Response to DPE

Ivanhoe Estate Redevelopment – SSD8707

**Response to the Department's Request for Information
Ivanhoe Estate Redevelopment – Concept (SSD-8707) and
Stage 1 (SSD-8903)**

Ivanhoe Estate - 2018/2019 Development Plan Changes

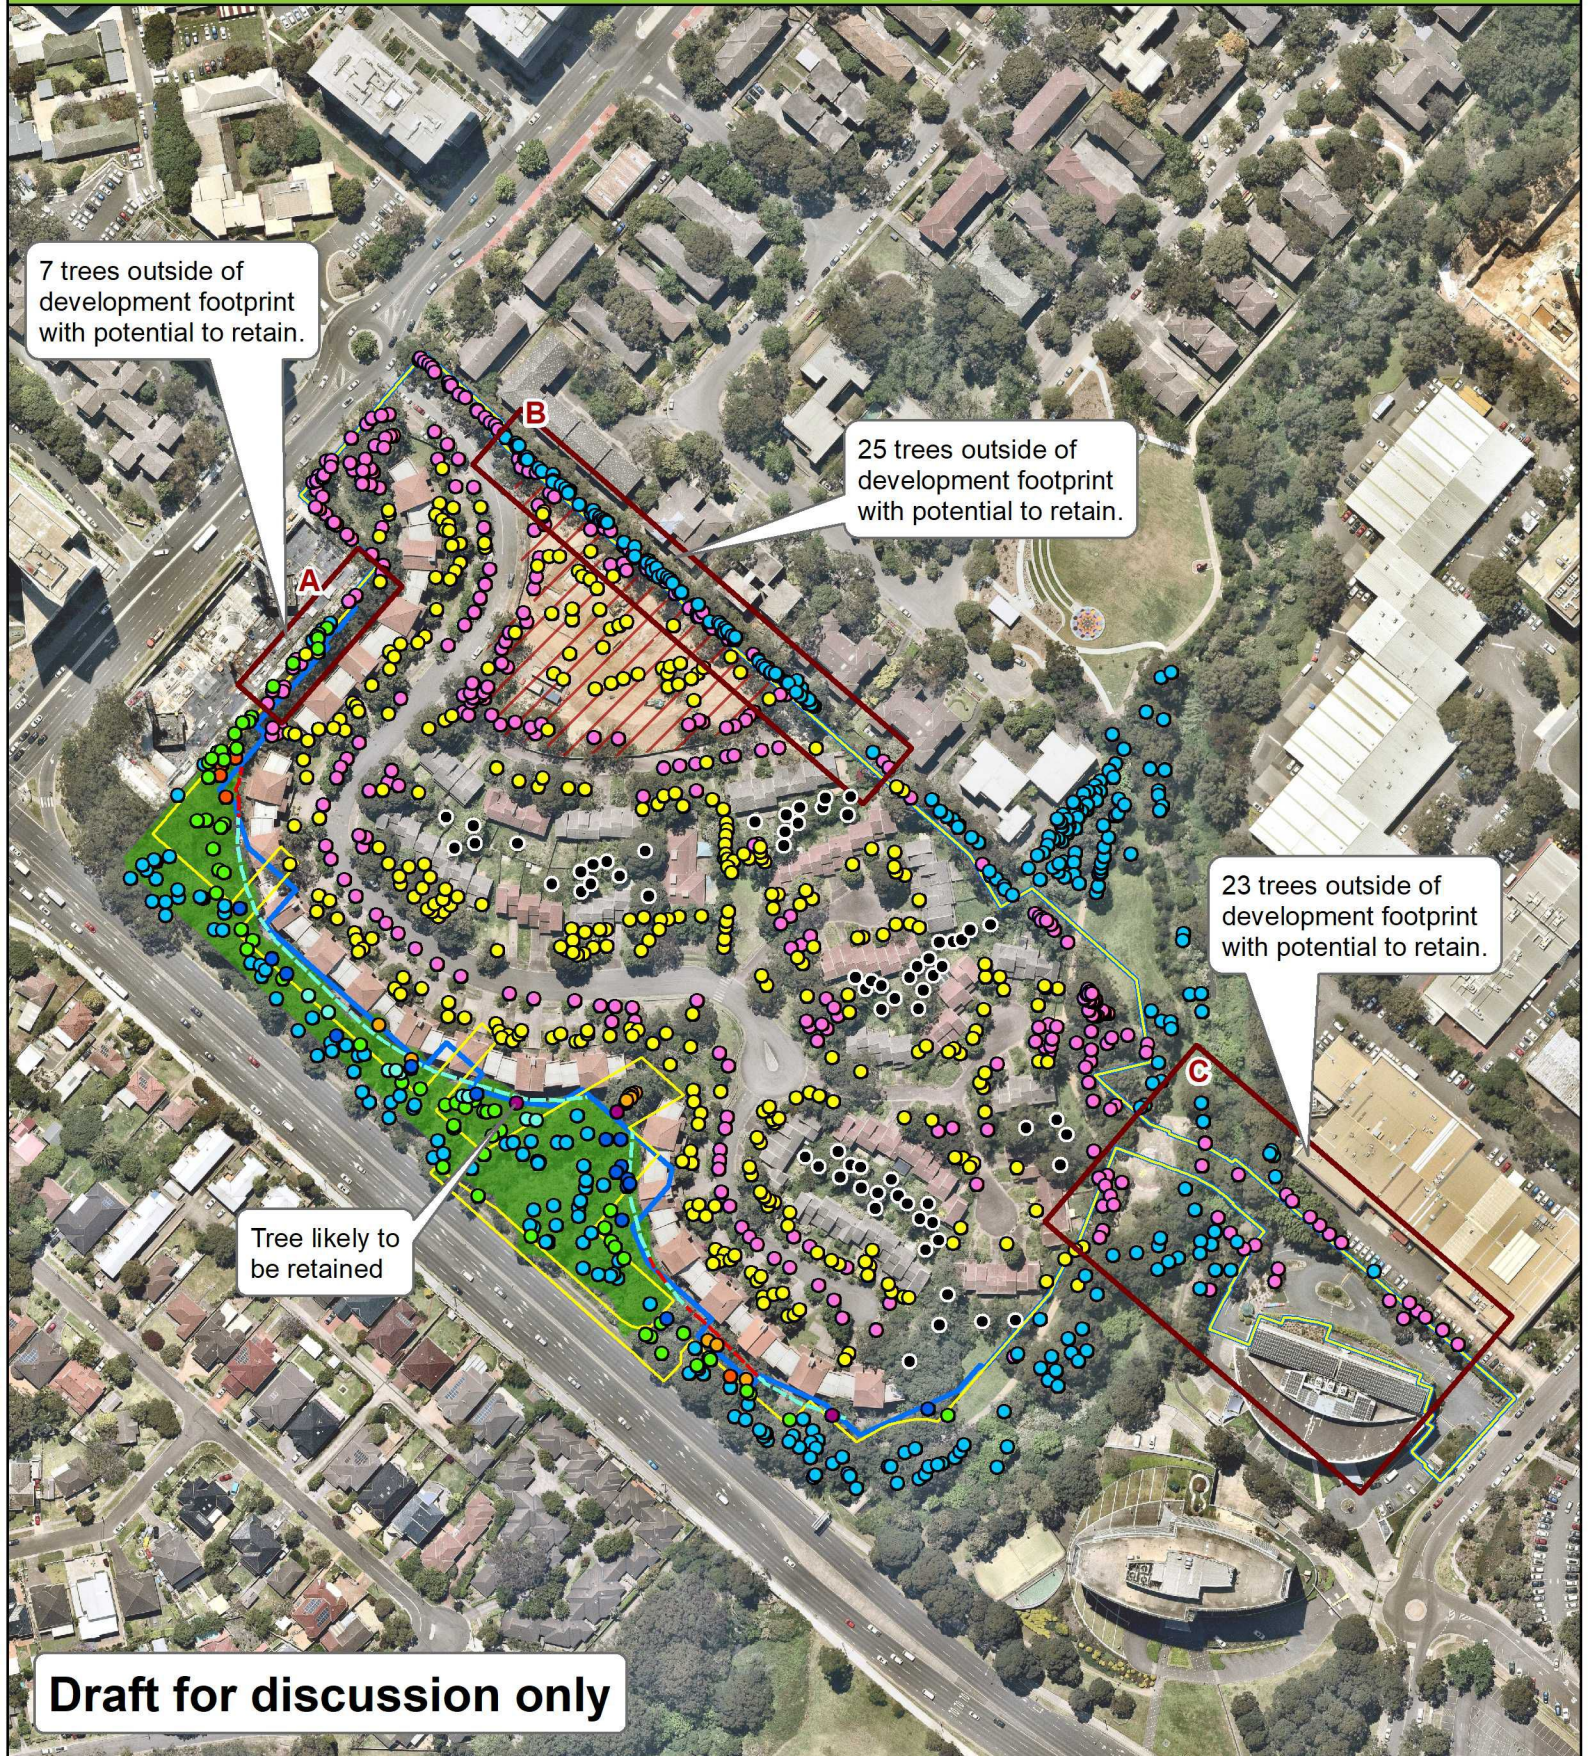
d) Provide a separate plan identifying the trees previously proposed to be removed as part of the demolition which now form part of the SSD and which of these are to be retained/removed.	Refer to Attachment A "Ivanhoe Estate – 2018/2019 Development Plan Changes"

01 NORTH WEST INTERNAL ELEVATION  
1:200

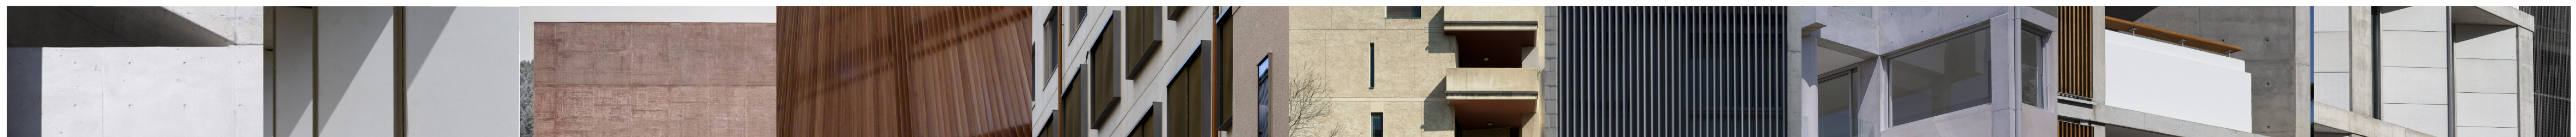
<p>b) Confirm how privacy will be achieved to ground level apartments on the eastern side of Building C1 which directly adjoin communal open space.</p>	<p>The eastern side of building C1 at the ground plane interfaces with an internalised communal open space area. Solid balustrades and mounded landscaping for these apartments is proposed to address privacy concerns. Refer to Attachment I.</p>  <p>01 NORTH WEST INTERNAL ELEVATION</p>
